**COMMENTS ON THE APPLICANT'S
DEADLINE 5 SUBMISSIONS**

SUGGESTED DRAFT S.106 AGREEMENT

DEADLINE 6

**A63 Castle Street Improvement Scheme
HULL
TR010016**

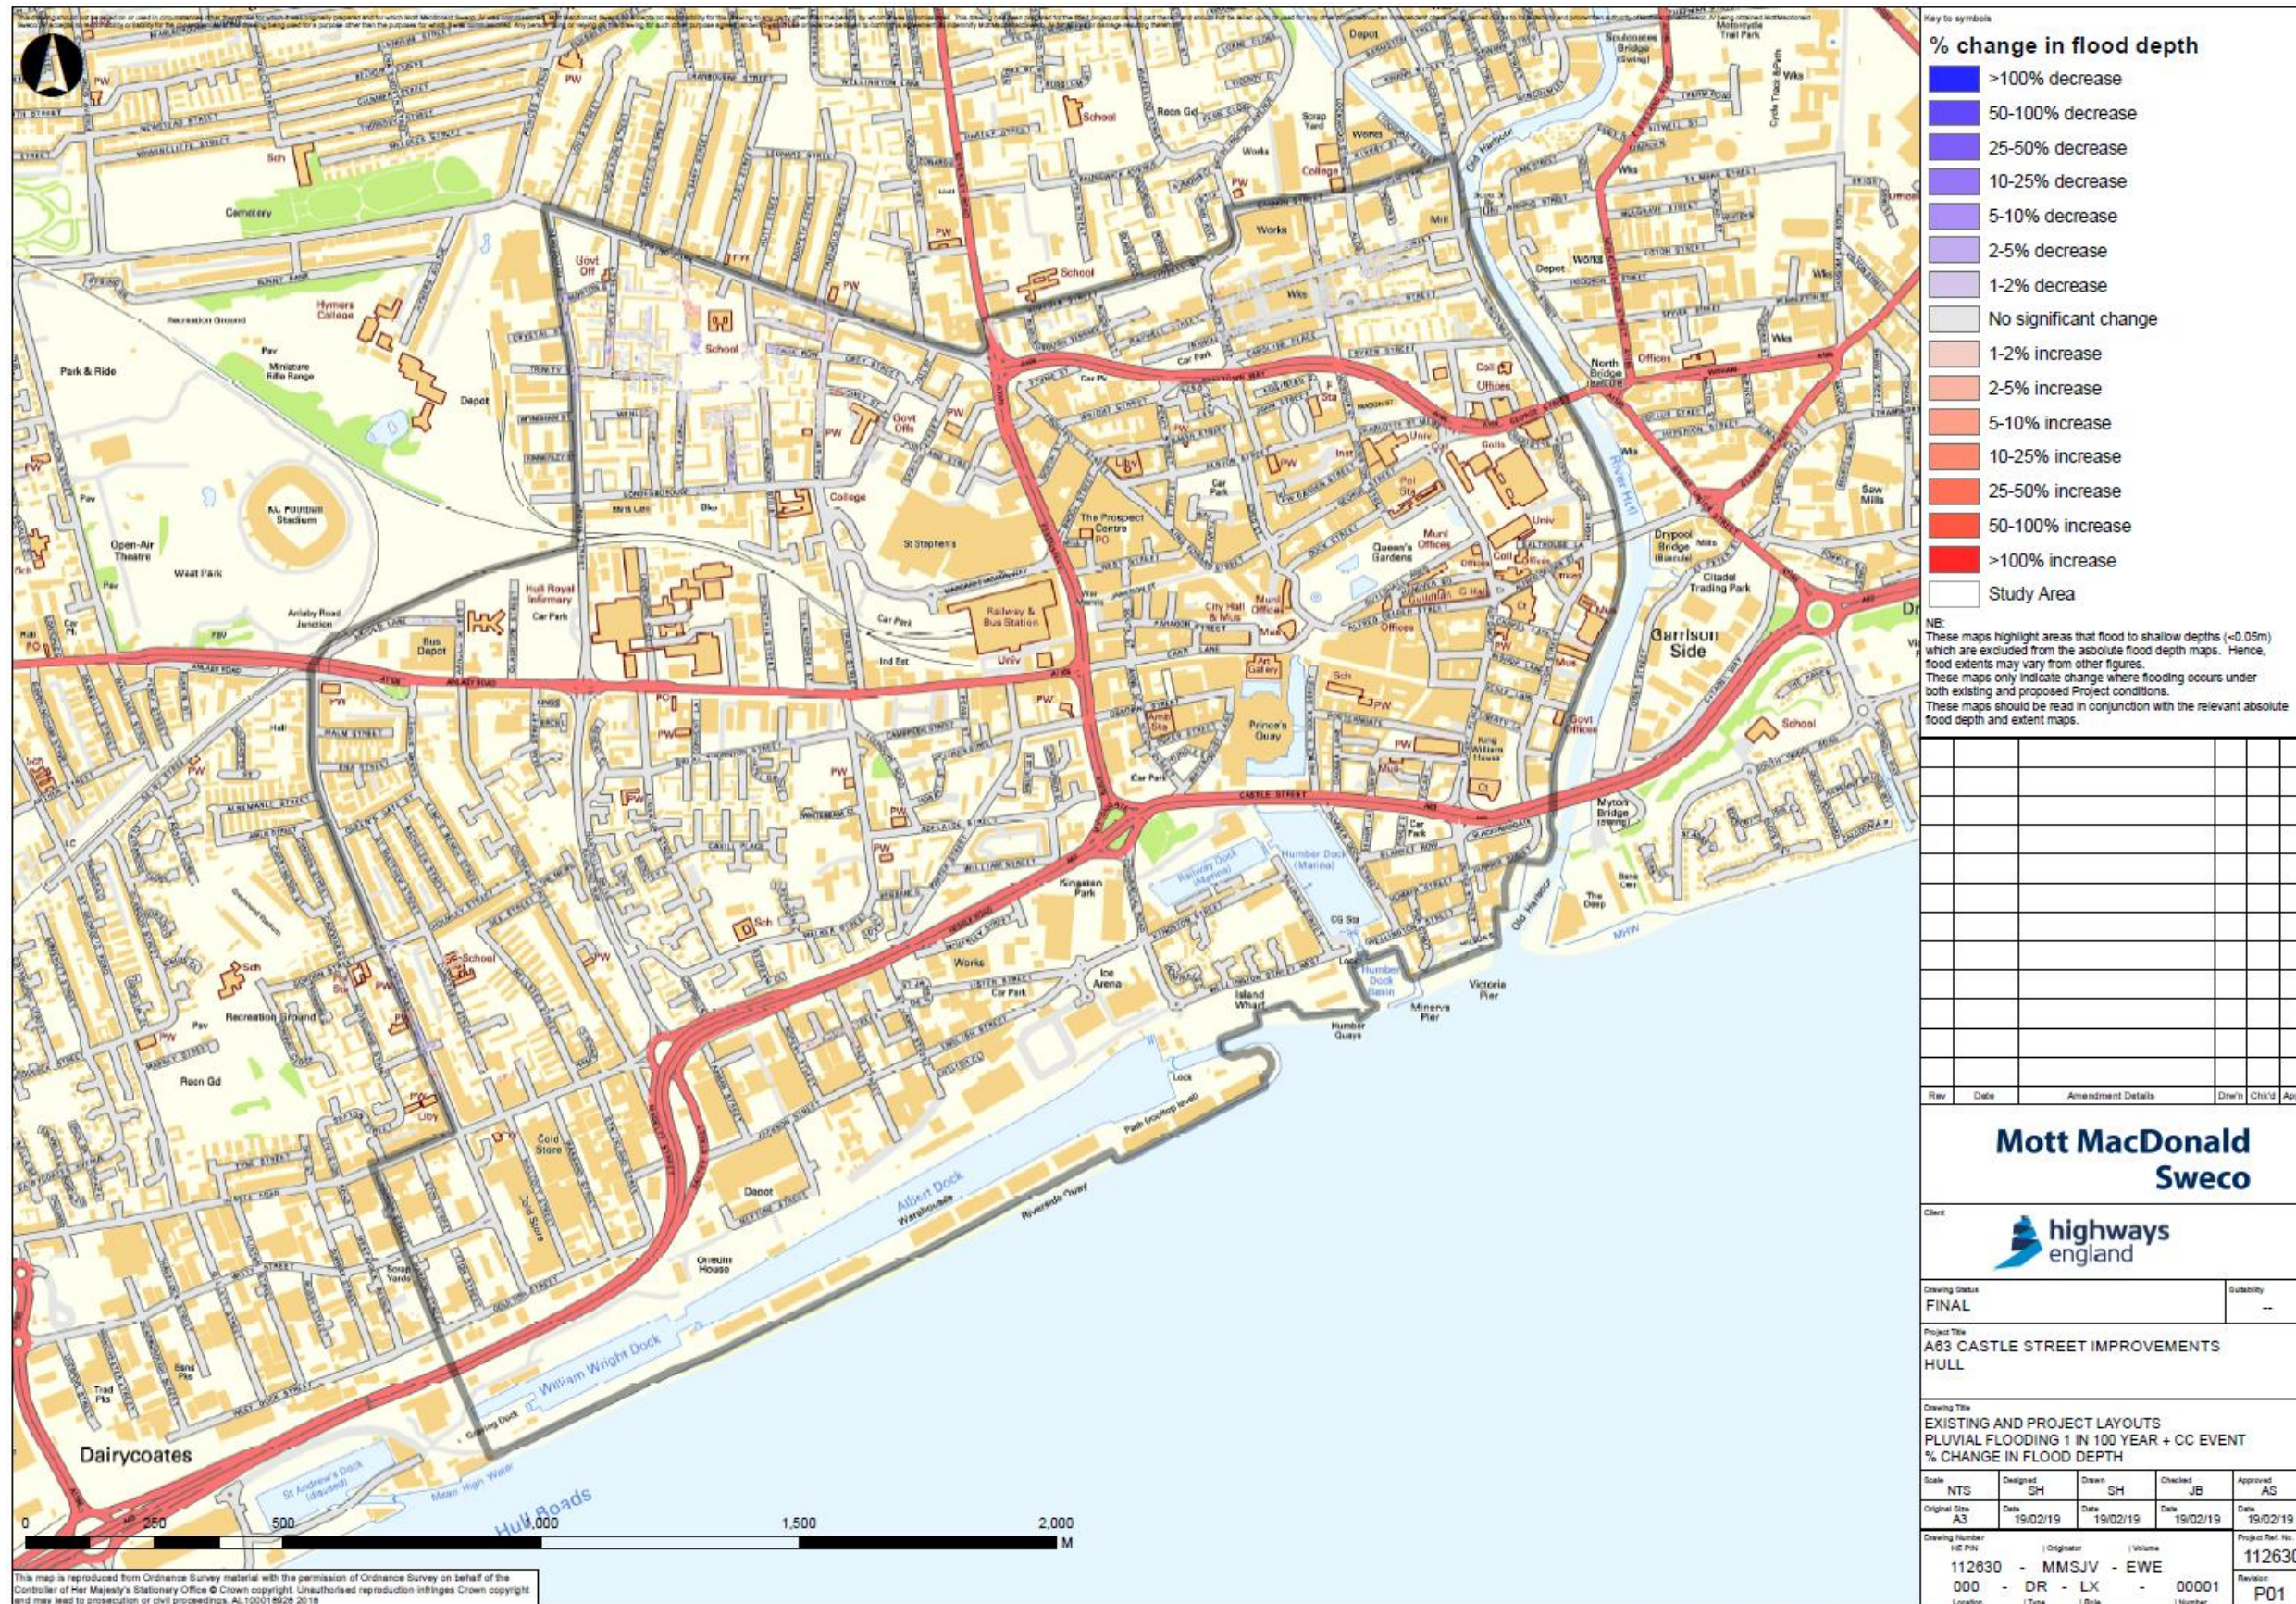
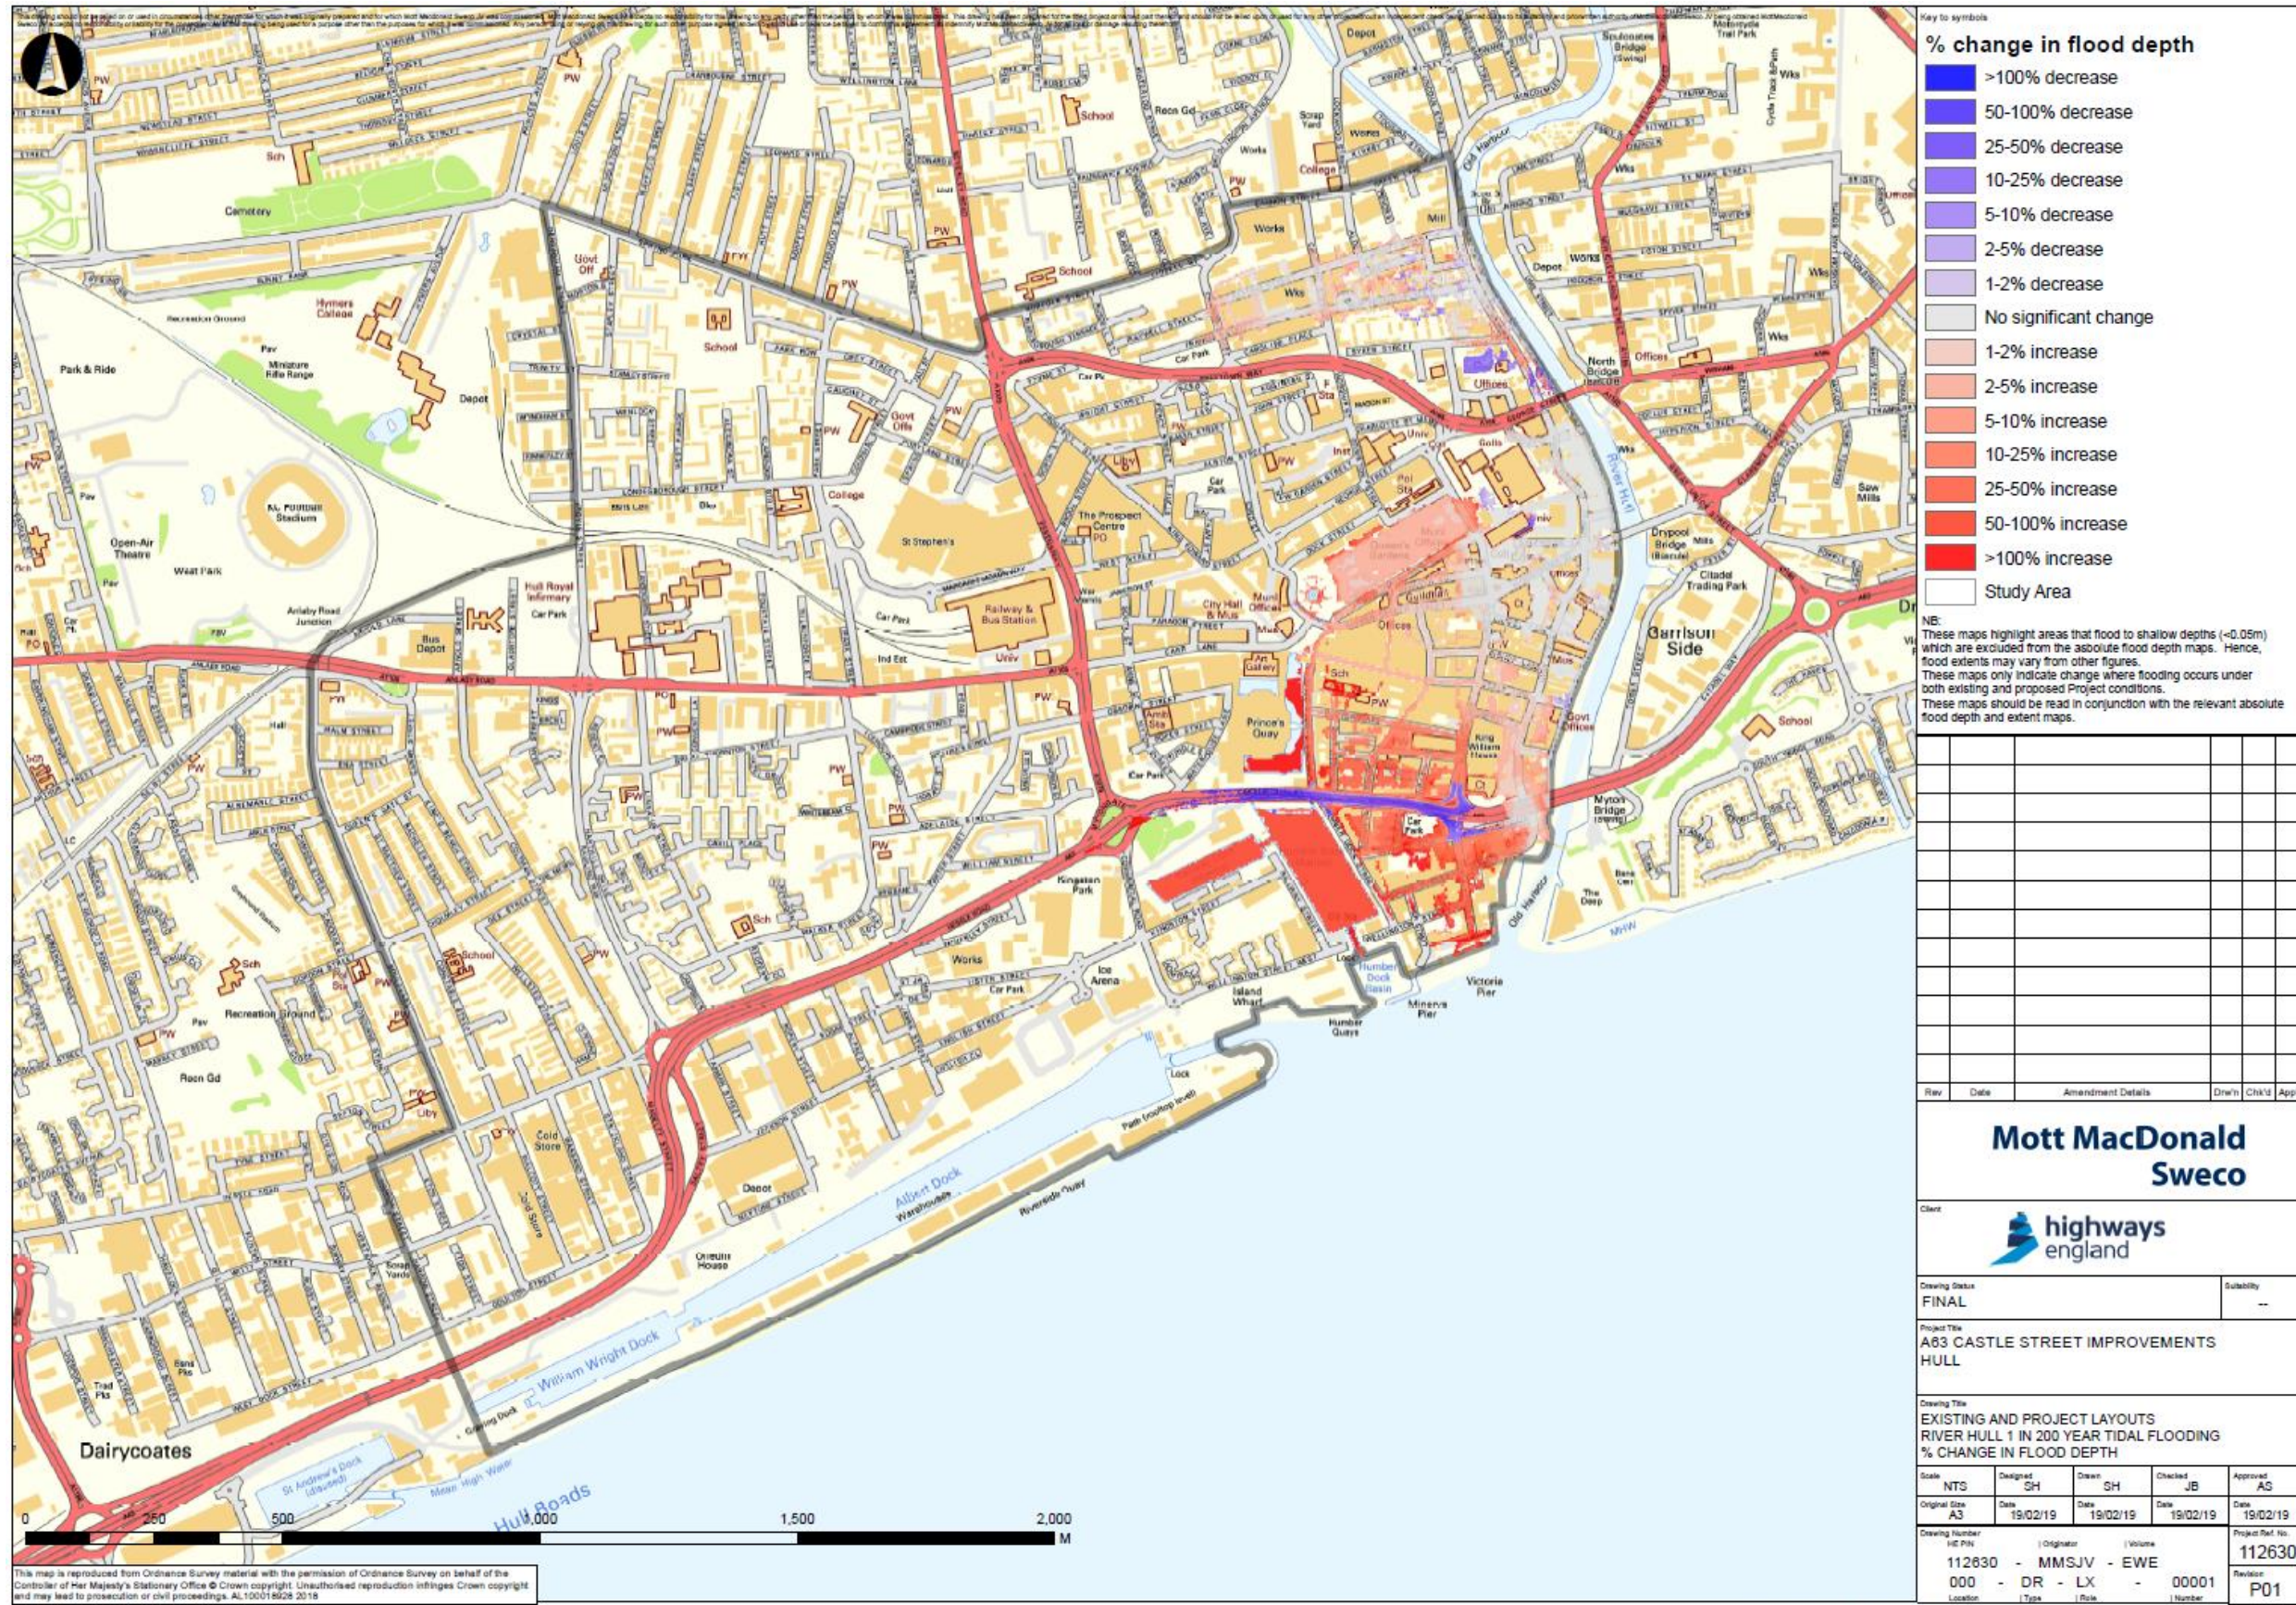
HCC welcomes the submission of the updated Flood Risk Assessment and related Technical Note. It is noted that the revised document makes specific reference to the proposed presence of a Vertical Concrete Barrier along the centre of the Trunk Road, and models the effect of the same under various scenarios. The ExA will be aware of recent and on-going discussions over the design of the central barrier.

HCC recognises the utility of a central reserve barrier, but in general terms would be supportive of minimising the height of any barrier in flood risk terms. This is because the barrier, in certain scenarios, can prevent flood water from being relieved by the full capacity of highway drainage infrastructure.

HCC also consider that the effect of the Vertical Concrete Barrier, whilst of limited material impact relative to predicted depths under the different scenarios modelled, would be less desirable than that of a barrier with solid elements of lower height, given that this would serve to reduce depths to the south of the A63, where impacts are predicted to be more significant.
